Application for a non-material amendment following a grant of planning permission.

Demolition of existing garage and extension. Extensions and renovation of existing property including raising of existing ridge height, dormer windows to front and rear elevations and a two storey rear extension.

Reference number:	FG/88/20/HH
Date of decision	29/09/2020

Amendment to proposed external wall materials.
Some walls previously indicated as being finished with white render are now proposed to be finished with Cedral lap cladding in white (C01)

Client: Ms L Spencer
Project Address:
15 Foamcourt Way
Ferring
West Sussex
Drawing Title:
Proposed Plans, Elevations, Roof Plan and Site Block Plan
Drawing Number: 1248.02.c
Scale: As stated printed @ A1
Date: 20/07/2020

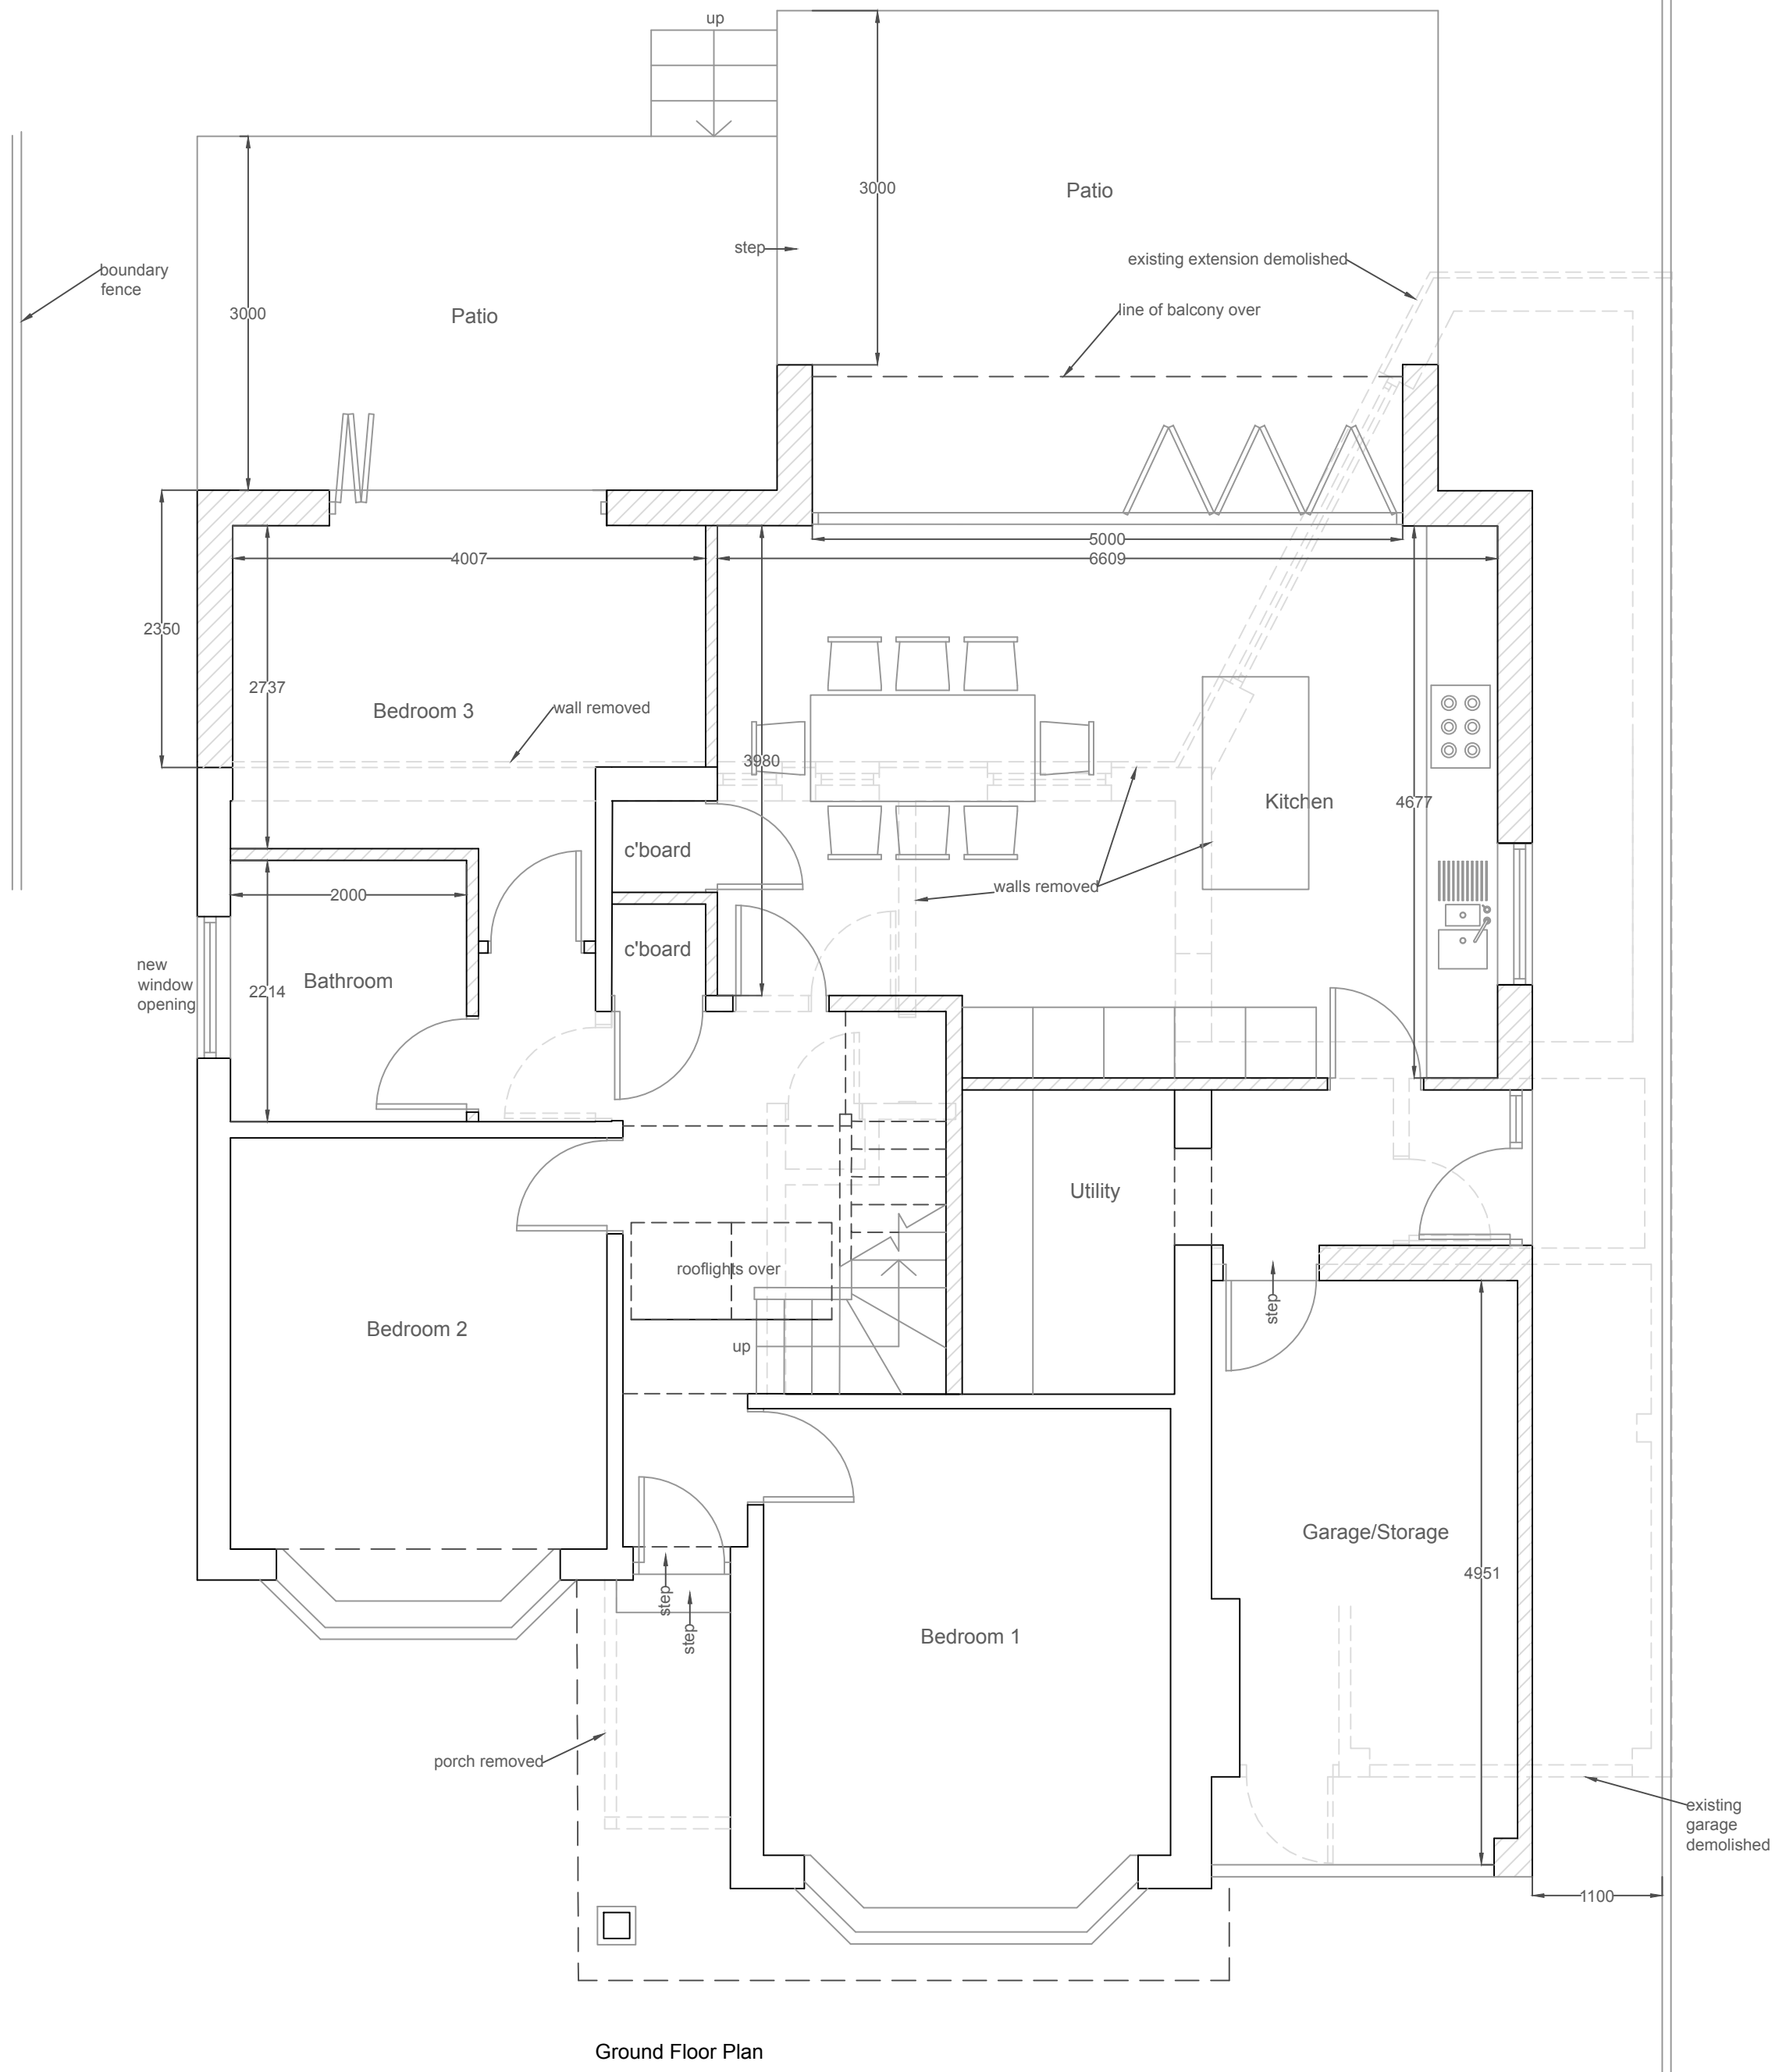
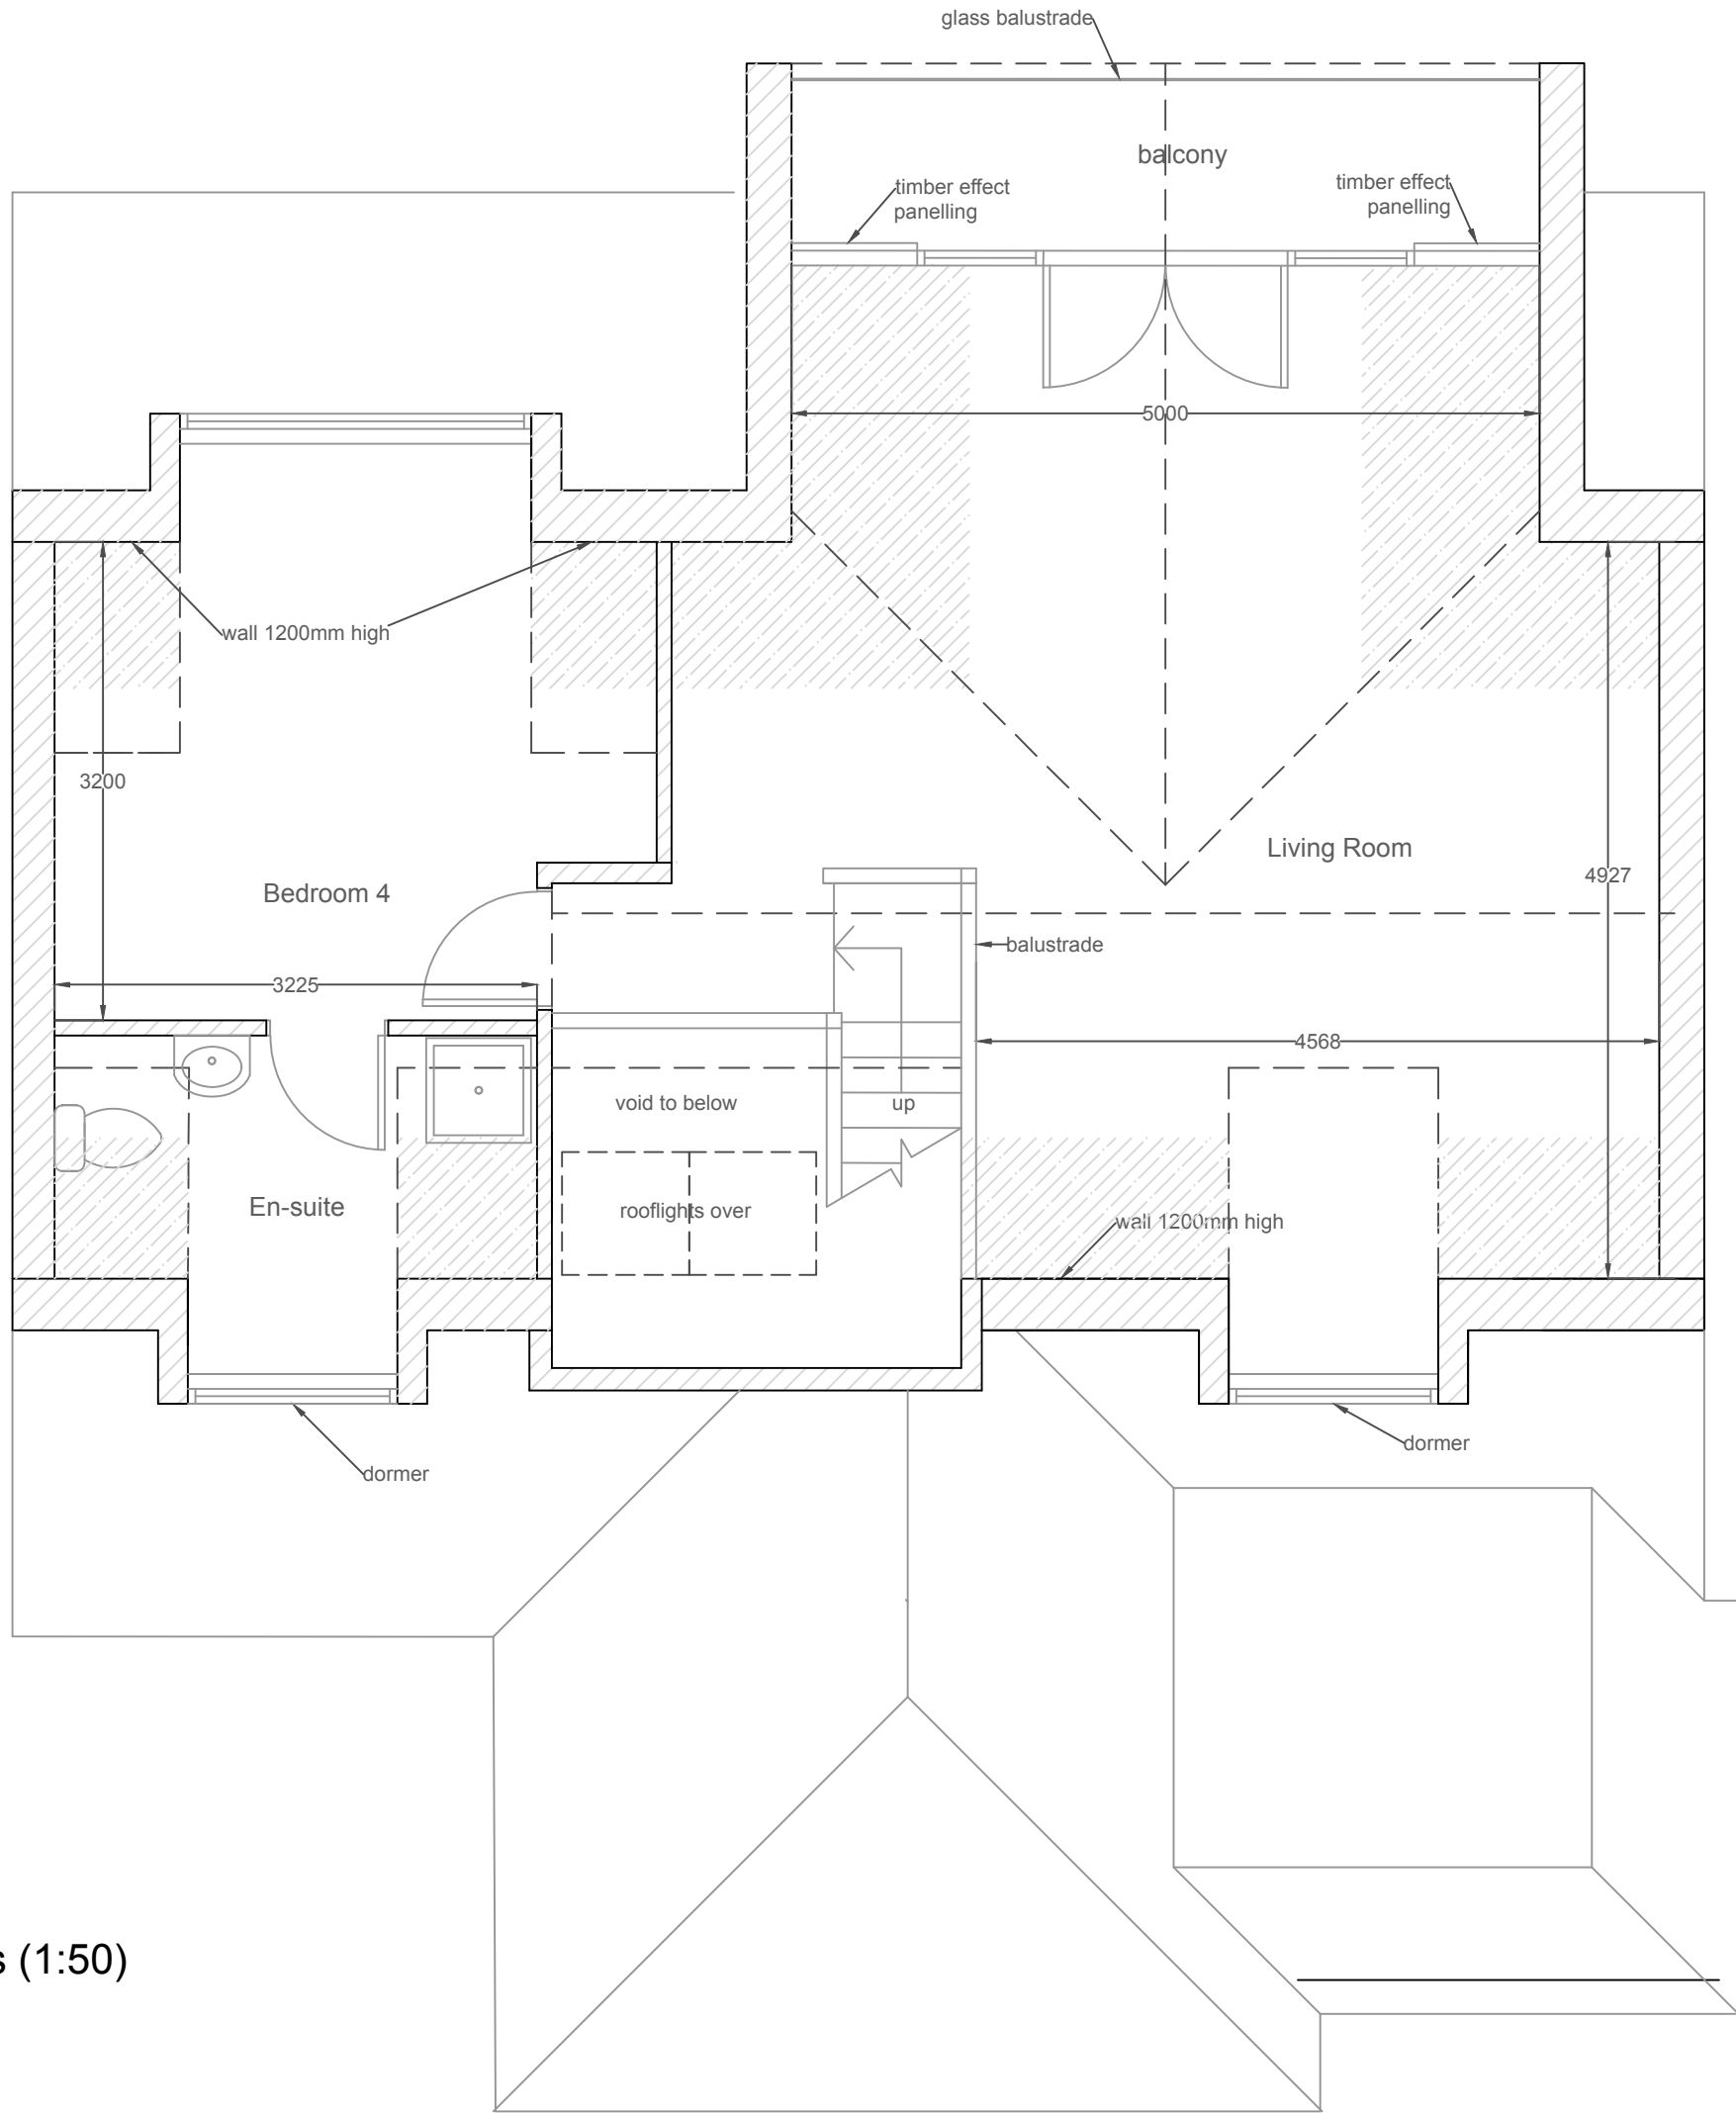
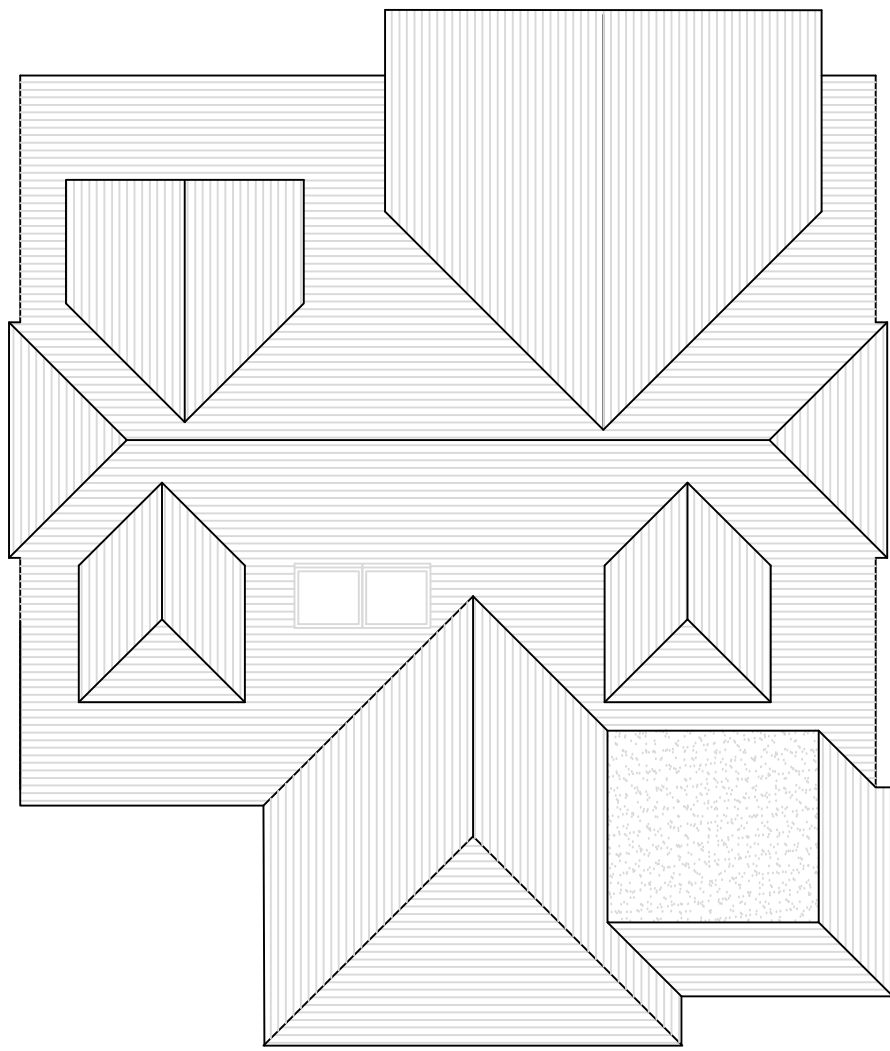
Old plan/drawing numbers

Proposed 1248.02.b

New plan/drawing numbers

Proposed 1248.02.c
